**Subject: WALLERAWANG BATTERY ENERGY SYSTEM – SHELL ENERGY Approval Modification –  
Amendment Report (SSD-14540514-Mod 1)**

Date: 23 September 2025

Figure 3-4 Plant Community Types (Arcadis, 2021)

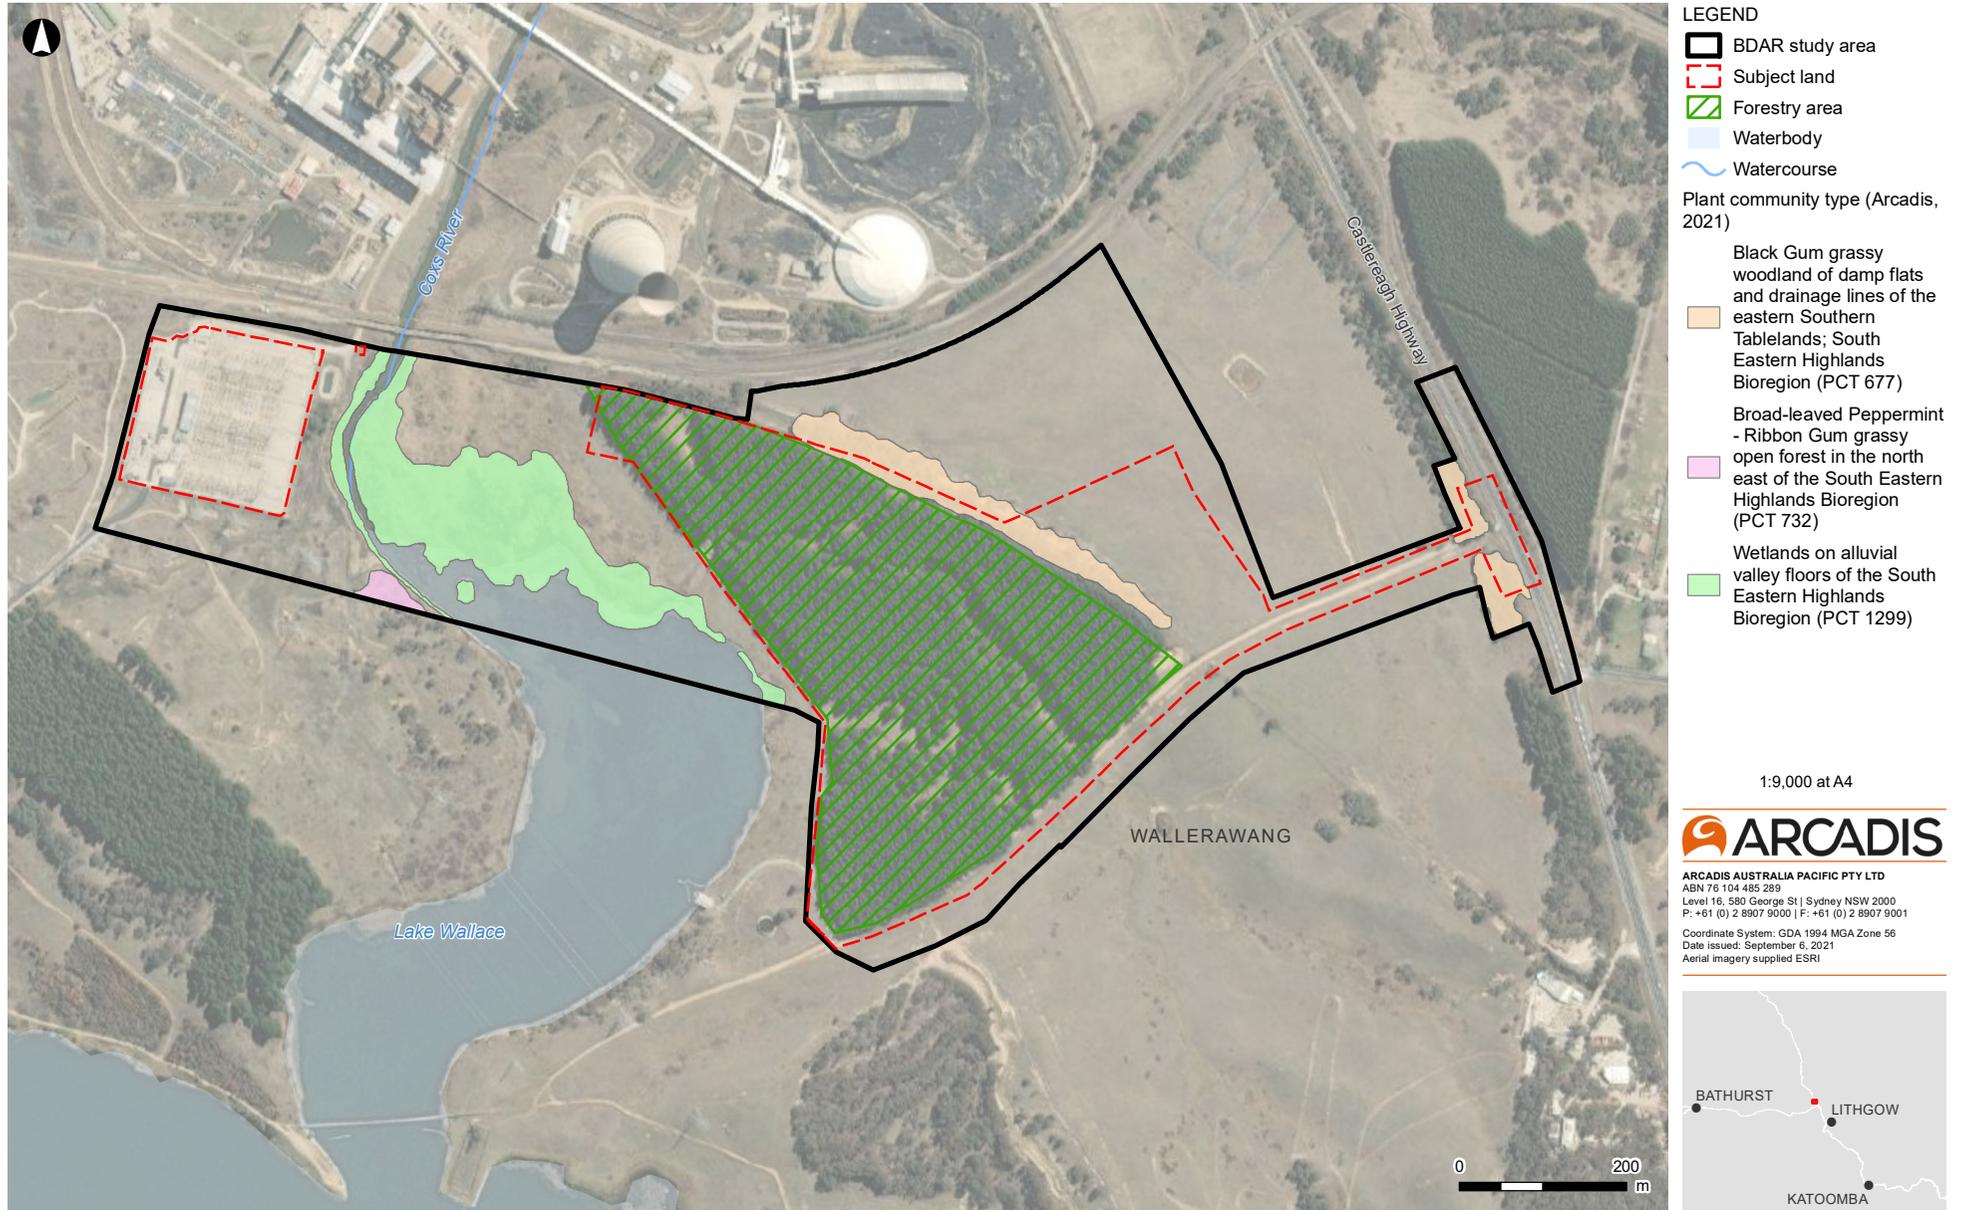
2	<p>The modified layout depicted in Figure 3.2 of the Amendment Report appears to intersect with vegetation consistent with Plant Community Type (PCT) 1299, as mapped in Figure 3-4 of the BDAR. CPHR is seeking clarification on whether there will be an increase in impact to native vegetation in the areas mapped in Figure 3.2 and described in Table 3.1.</p> <p>If the project increases impacts to biodiversity values, a BDAR may be required in accordance with section 7.17 of the <i>Biodiversity Conservation Act 2016</i>.</p>	<p>The locations of the transmission line structures remains unchanged from the locations proposed in the Modification Report. However, to allow for some flexibility and to accommodate disturbance during construction of the transmission line structures, the transmission line corridor was shifted south by 15 metres. This area has been previously assessed in the original Biodiversity Development Assessment Report (Arcadis, 2021).</p> <p>Figure 1 below compares the extent of vegetation zones for the EIS / Modification Report (red dotted line) and the Amendment Report (solid black line). As shown, the location of the transmission line structures remains unchanged from that shown in the Modification Report and the area of disturbance assessed in the Addendum BDAR, also remains unchanged.</p> <p><b>Impacts to PCT 1299, are consistent with what was assessed in the Addendum BDAR and as such, a subsequent BDAR is not required.</b></p>	<p>Addendum BDAR (Arcadis, 2025)</p> <p>Modification Report (Arcadis, 2025)</p>
